**Re: 4071.10 – The Asylum – Level III Development Review Application
Conditions of Approval**

On May 24, 2016, the City of Portland Planning Board granted site plan approval for the proposed Asylum project at 121 Center Street. To summarize, the applicant is proposing to demolish a portion of the existing 1-story building near the intersection of Center Street and Free Street and replace it with a larger 2-story building addition, construct a new 1-story building addition off Lancaster Lane and construct related site improvements. The Planning Board approved the application with a number of conditions (see below). Enclosed are updated approval drawings that address these conditions.

A11 NEW CATCH BASIN
NO SCALE

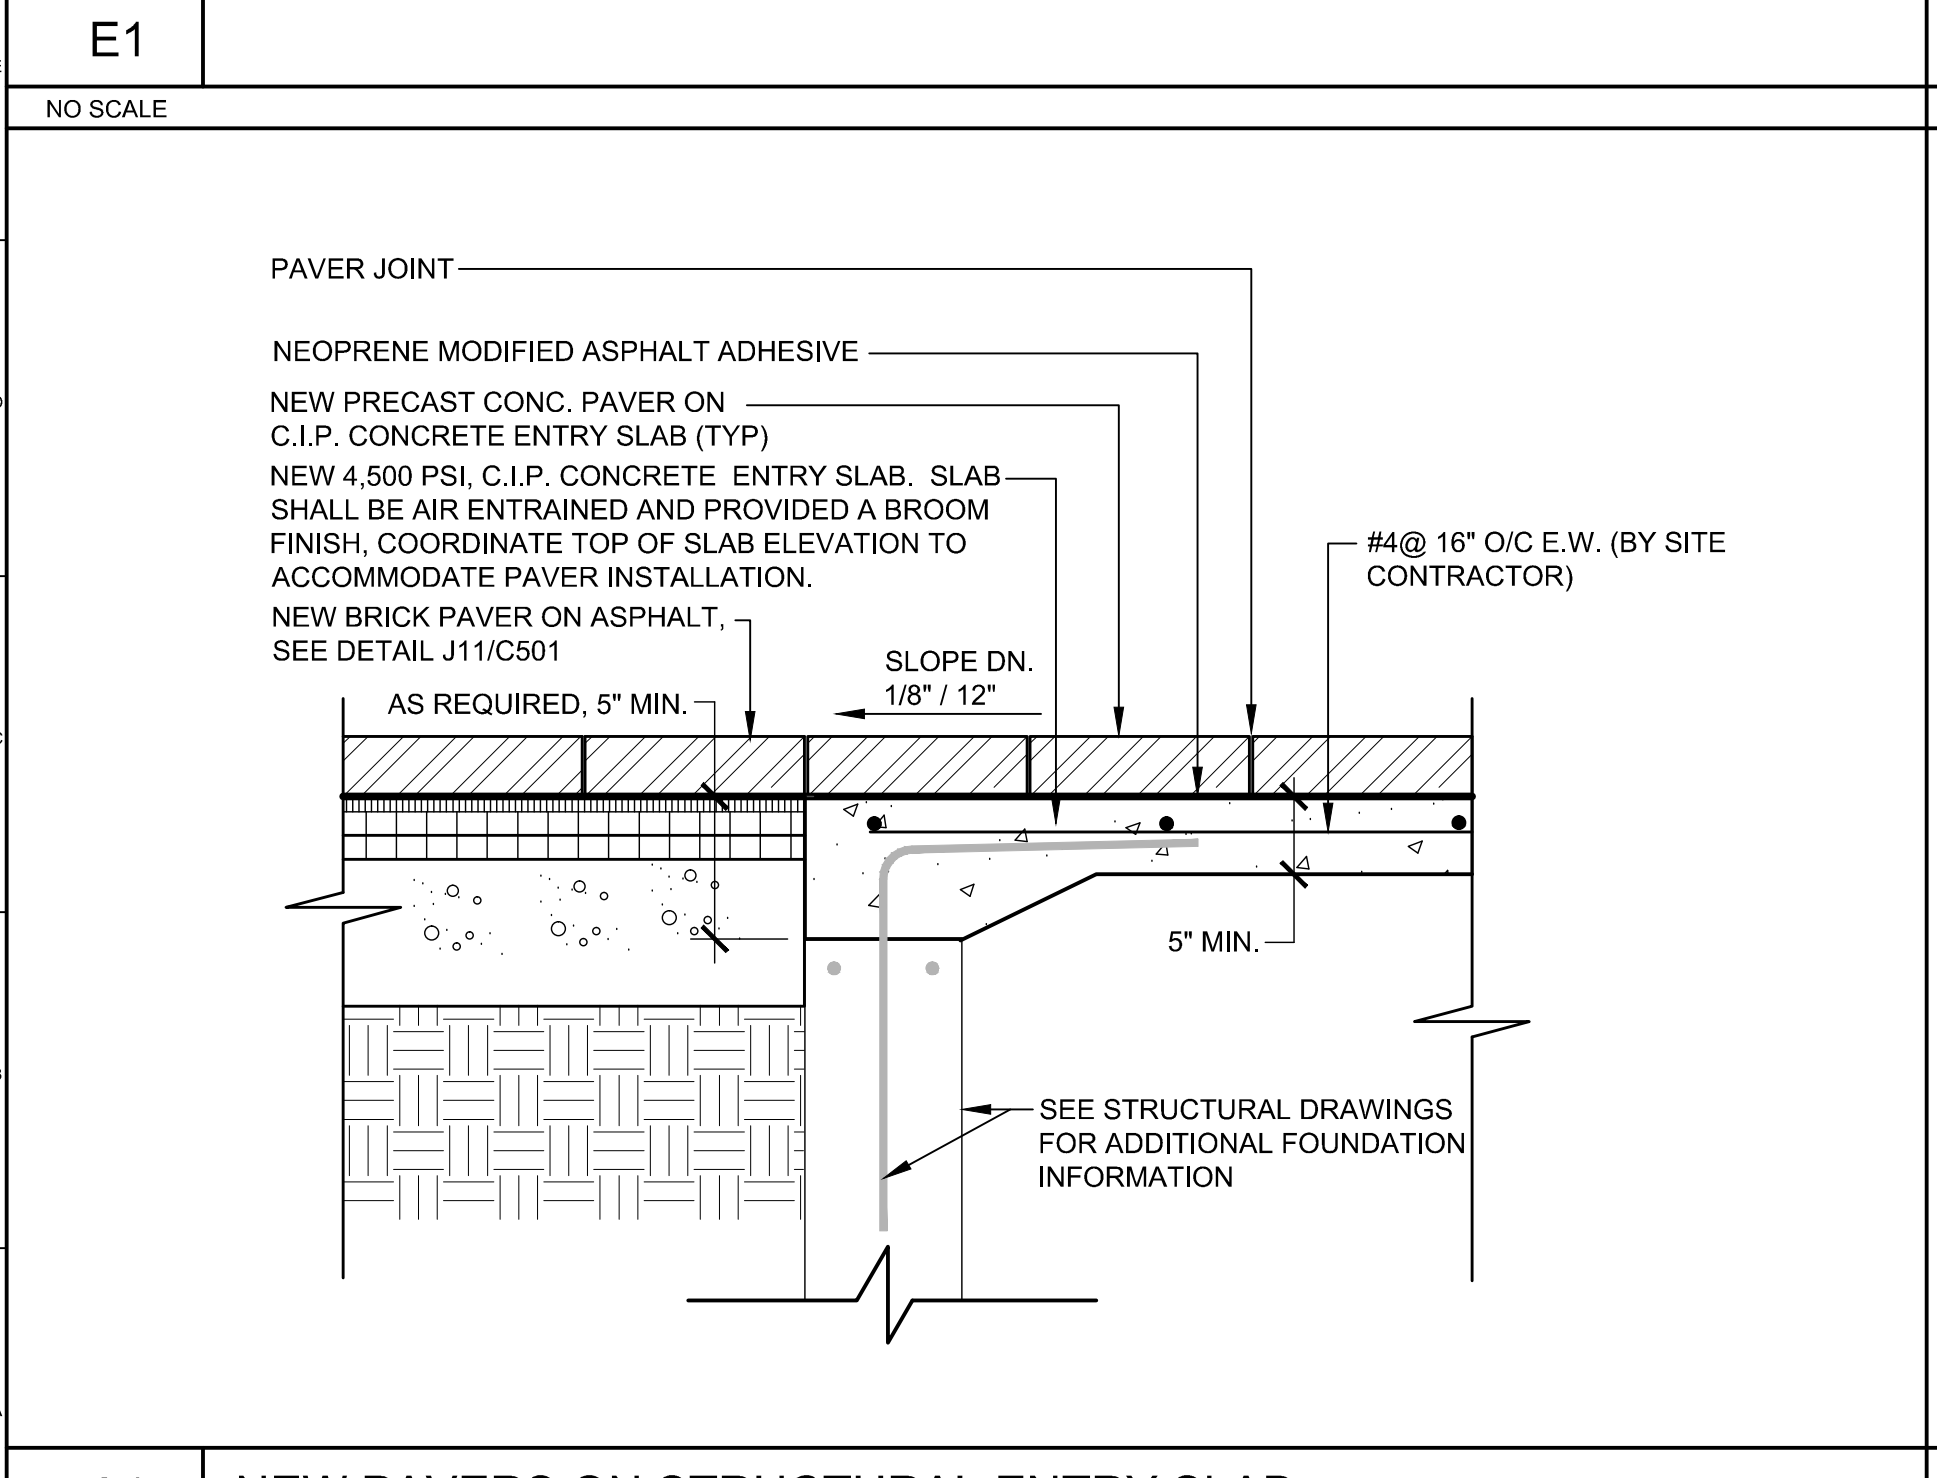
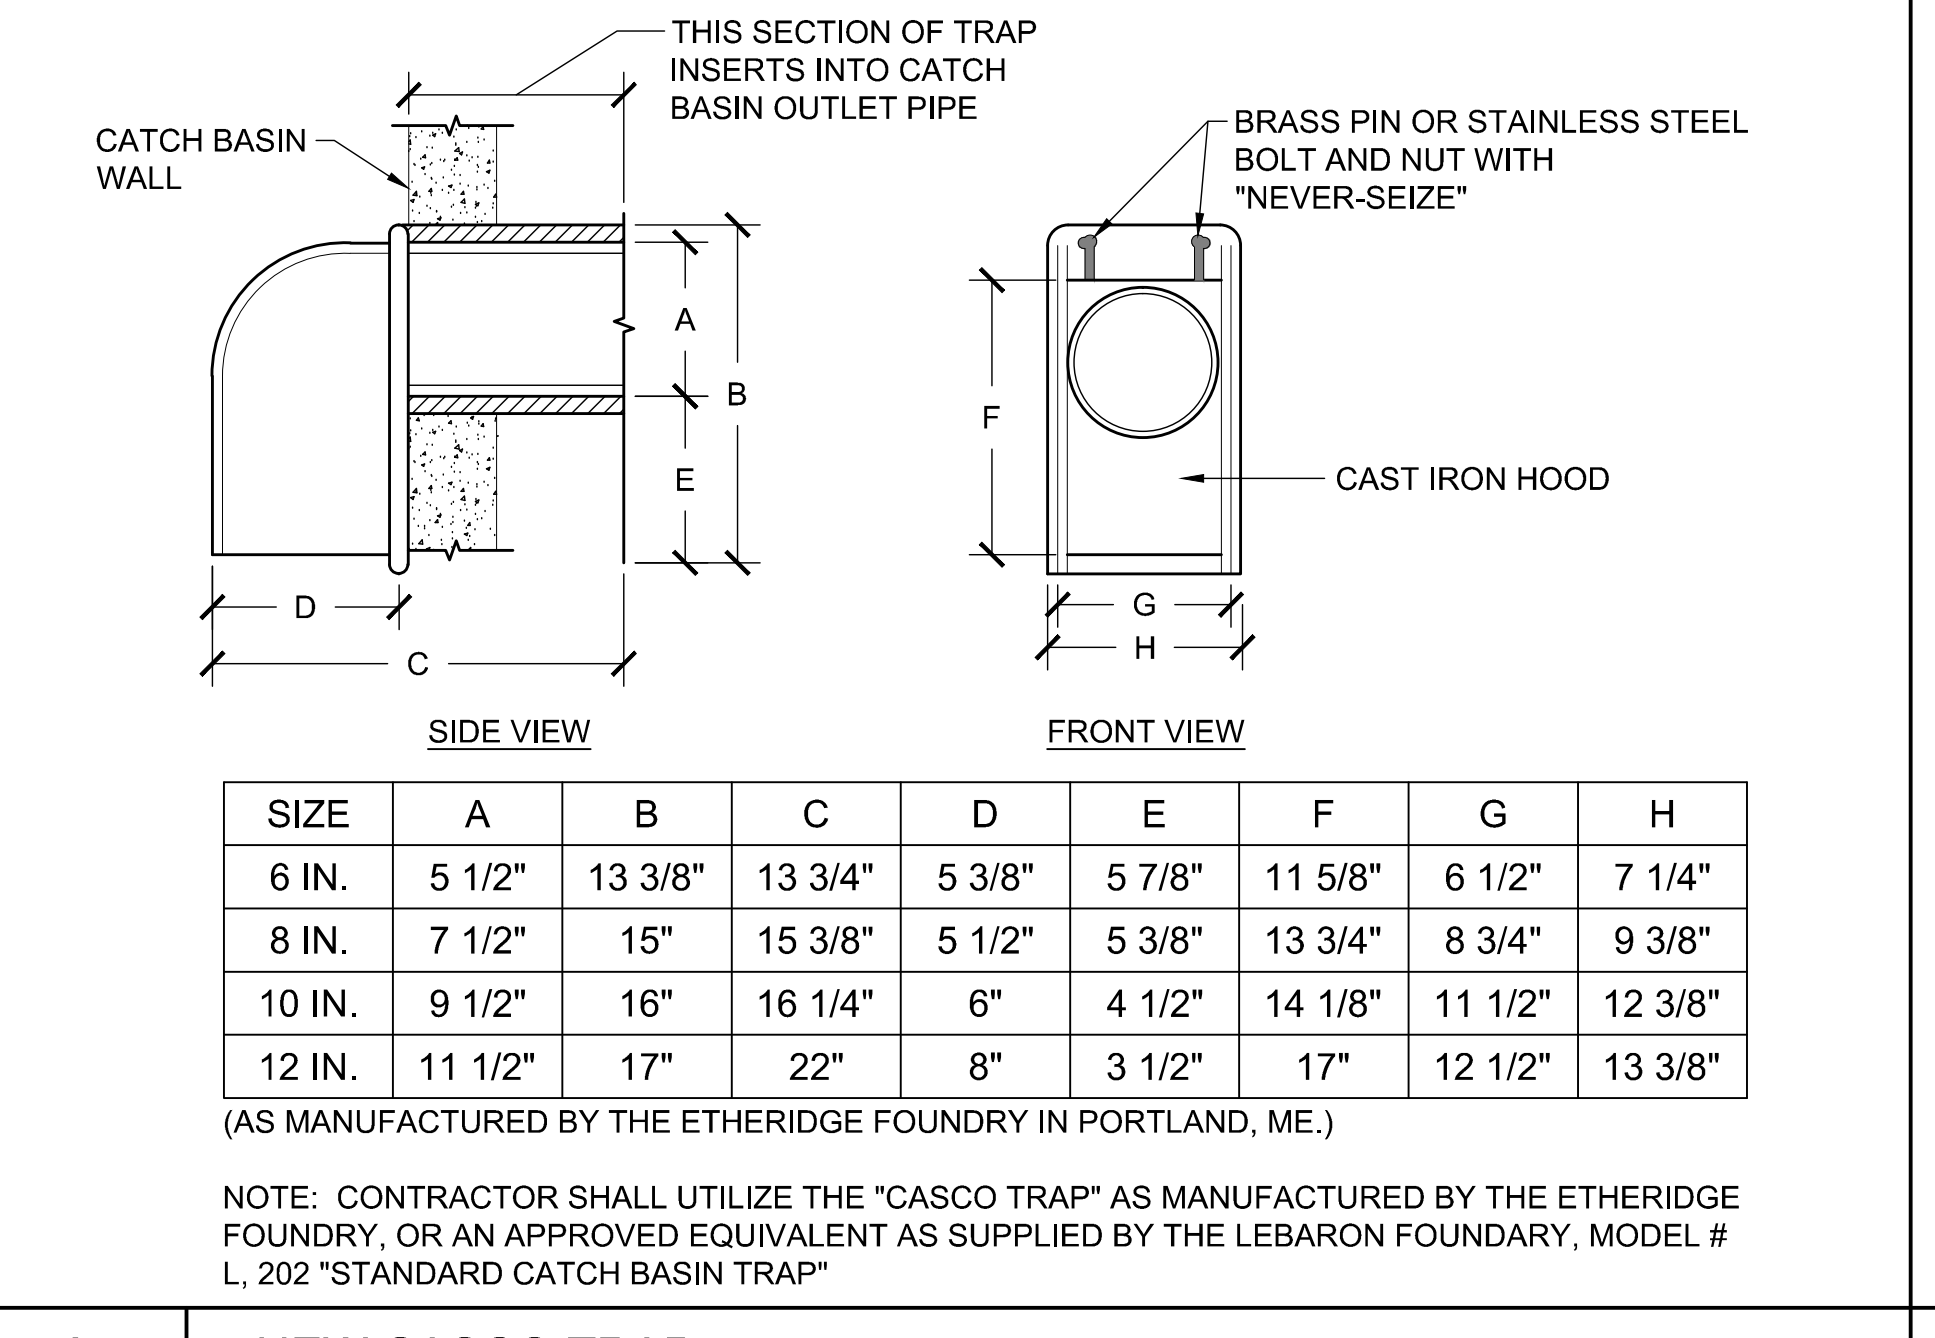
9. That the site plan shall be revised indicating details for the erosion control features specified on the site for review and approval by Lauren Swett, Development Review Engineer. **We added detail E5/C502 to provide additional information for the proposed Filtrexx inlet protection.**
